Application No: AW/87/20/HH
Site Address: 2 Priory Close Aldwick West Sussex PO21 4HH
Description of works: Single storey front & rear extensions & detached outbuilding.

Thank you for your internet representation made on 6th May 2020 which has been recorded as an objection with the comments as follows:

PROPOSED DETACHED OUTBUILDING AT 2, PRIORY CLOSE, ALDWICK BAY
FOR MR. & MRS. A. MARTIN.

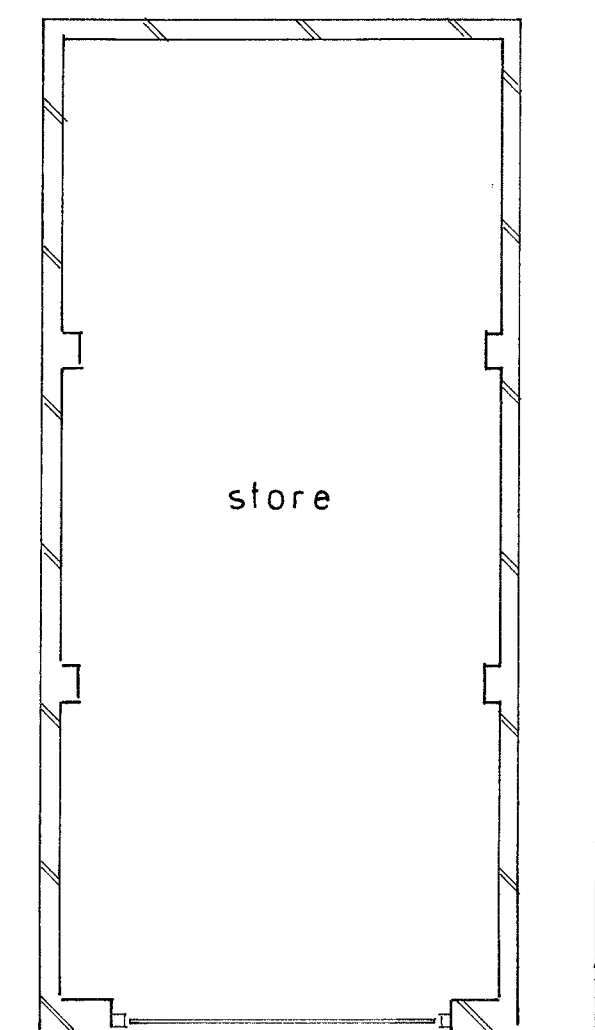
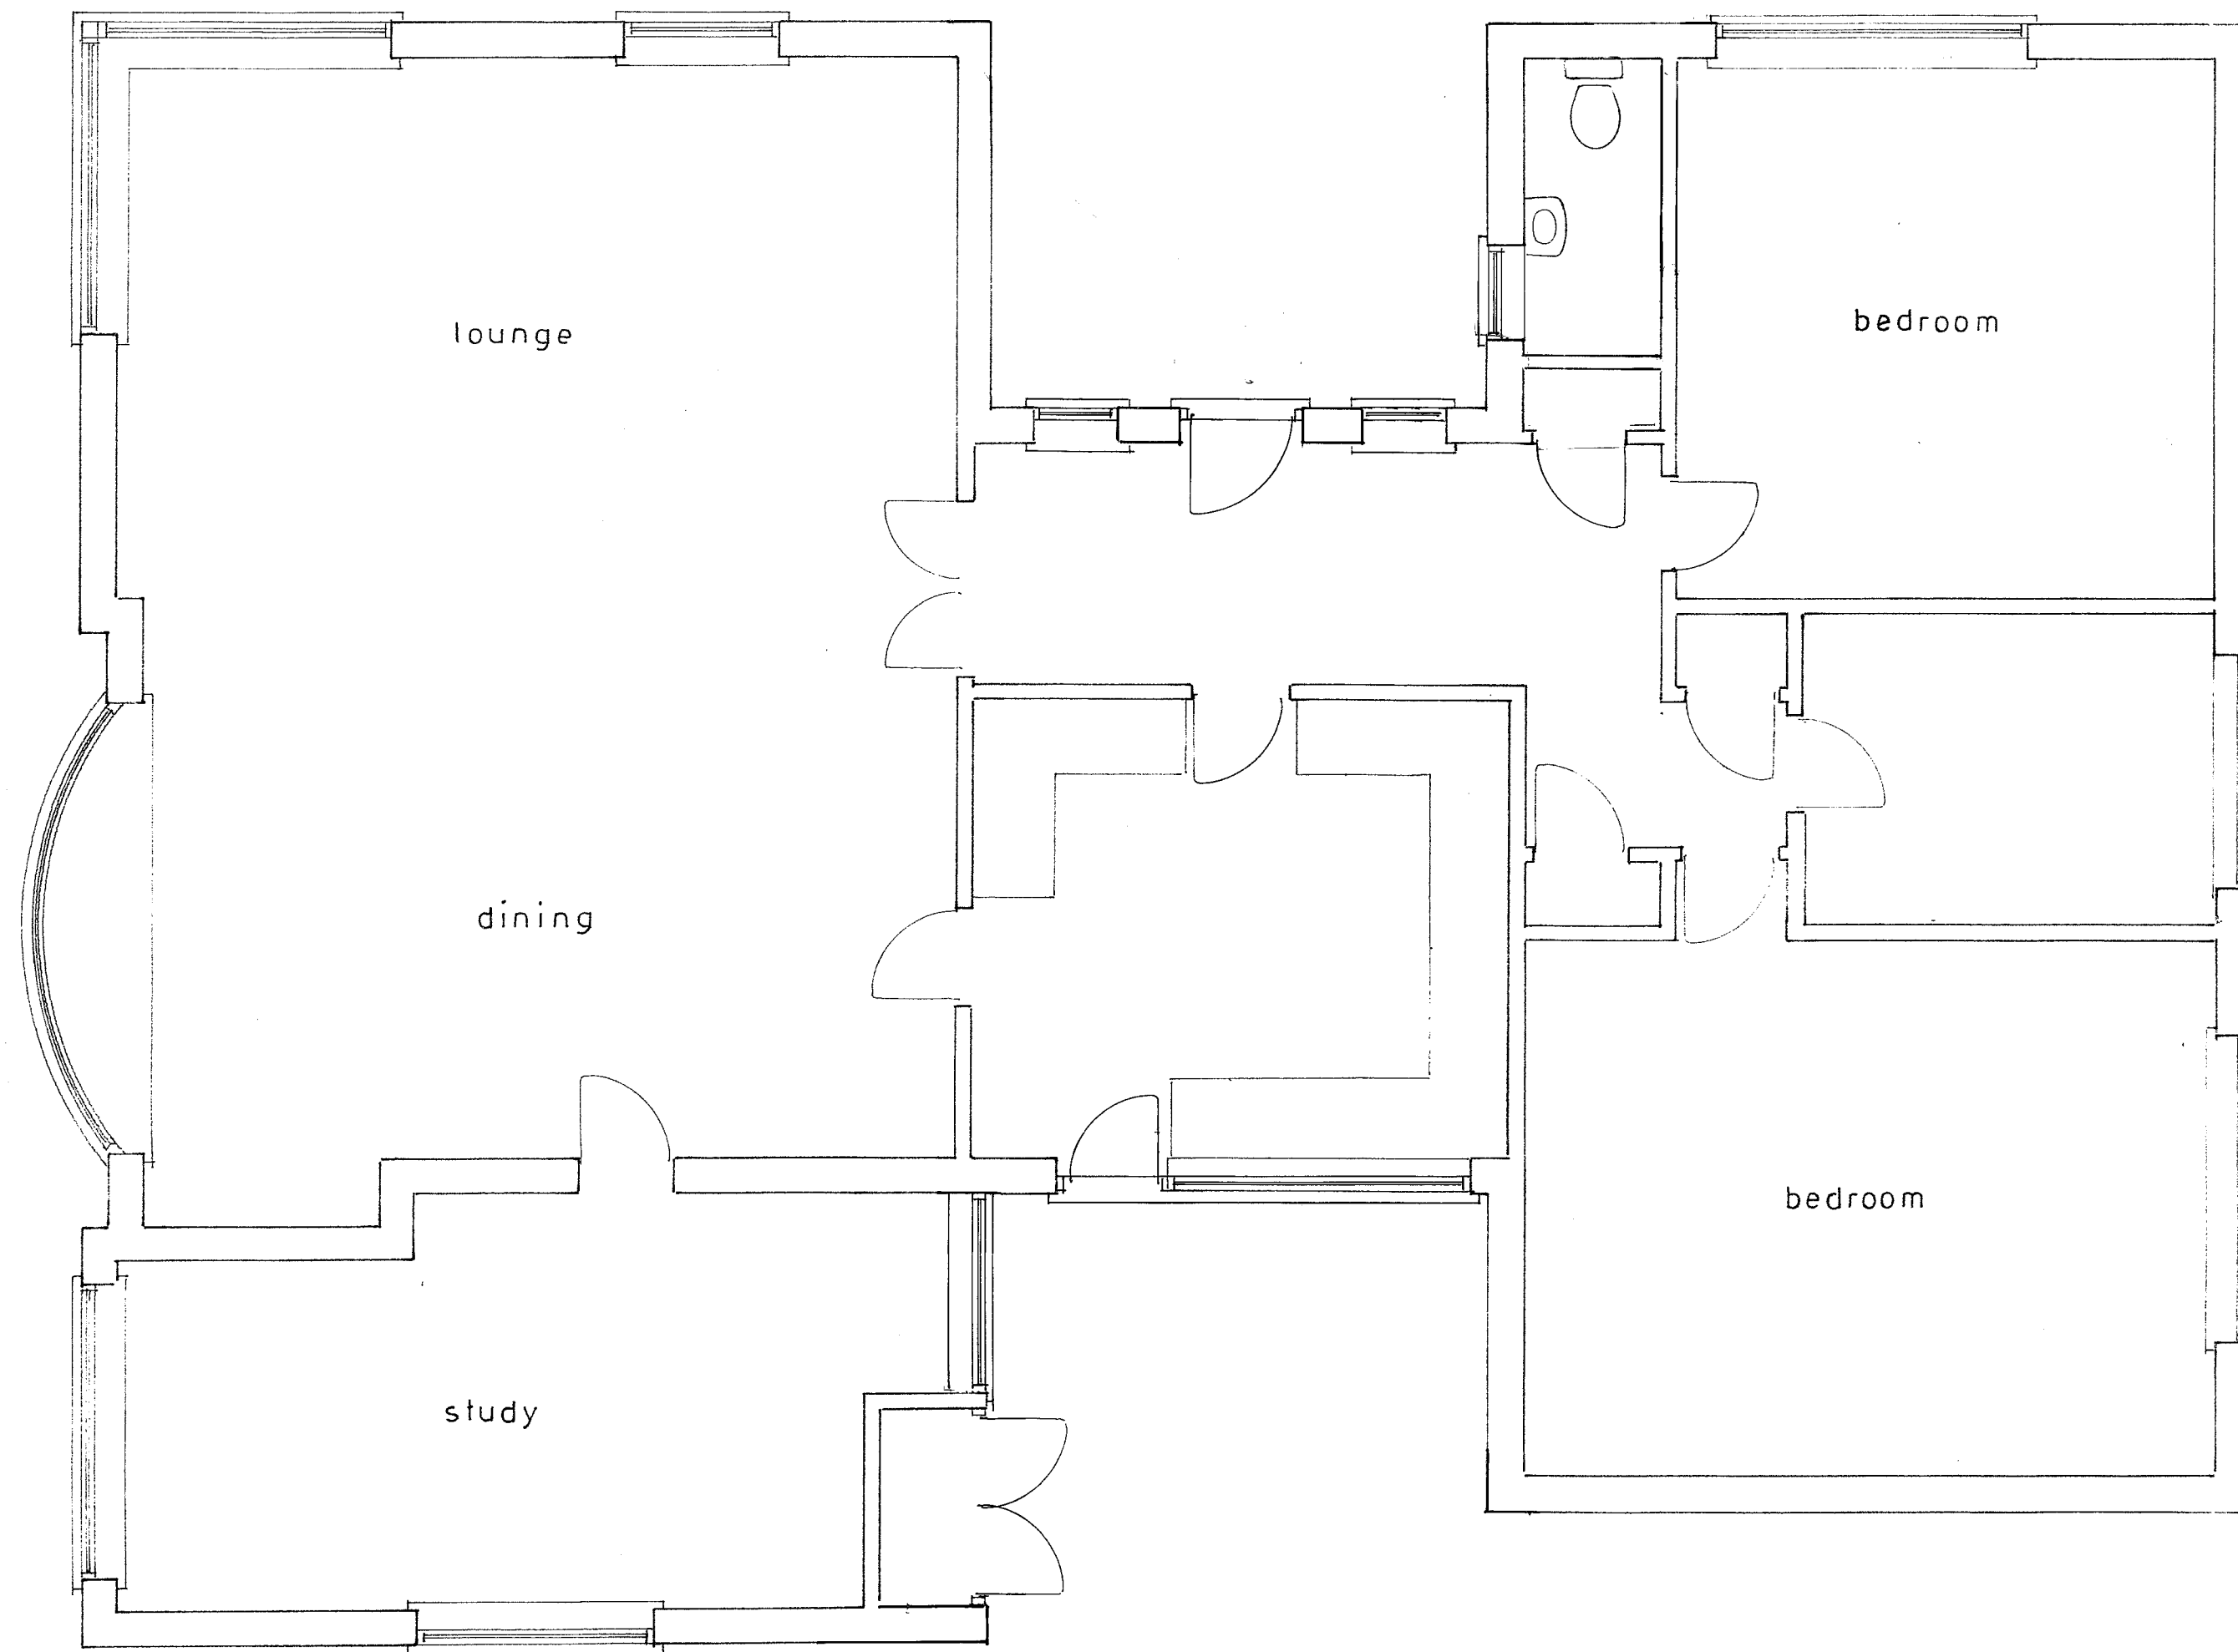
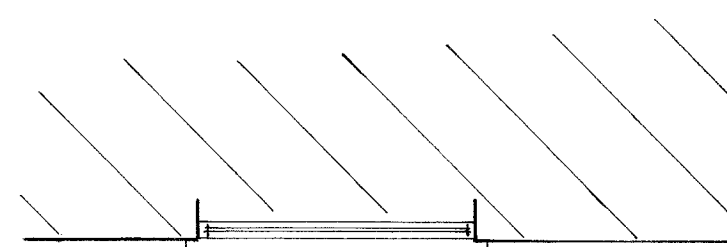
My wife and I are very concerned about the proposed detached outbuilding which will run parallel with our garden wall for a distance of 7200mm. It is variously described as a store or an outbuilding and is rectangular in shape. Currently there is a wooden garden shed in the garden of 2, Priory Close, with a pitch roof which is totally acceptable. The location of this shed is in the same position as the rear of the proposed outbuilding. Already provision has been made to provide electricity to this proposed outbuilding. Our concerns are that once constructed, it will not be used as a store, but will be used as a workshop with resultant noise or will be used for the purposes of running a business. It could also be converted into a dwelling. The proposed development is too near to the brick built wall, being 500mm from my wall and the wooden fencing bordering no 4 Priory Close. My concerns are that in construction, the footings of the proposed building will affect the footings of my garden wall and cause it to become unstable. I am also concerned that if I needed to maintain

my wall on the side of the proposed development, that 500mm is not wide enough to carry out that maintenance. The rectangular shape with a flat roof is ugly and the proposal of an up and over door to the west of the structure indicates use as a large garage and is also ugly. The up and over door is approximately 38m from the roadway in Regis Avenue to the west, but will not be used as a garage because of brick built walls between the proposed outbuilding and the roadway. There is no indication on the plans of the height of this building. I note that the proposed north side of this outbuilding will match the existing dwelling. No mention is made of materials to be used for the east, west or south side; to cut costs, block may be used. The view of this building from my living area and garden will be very unsightly.

There are no other detached permanent structures adjacent to houses in Priory Close or Regis Avenue in such a position and with uncertain use. By allowing this outbuilding, it is setting a precedent for other similar buildings to be constructed in this area. This ugly building will clearly be seen from the roadway in Priory Close, is not in keeping with the area and is not suitable for a rear garden.
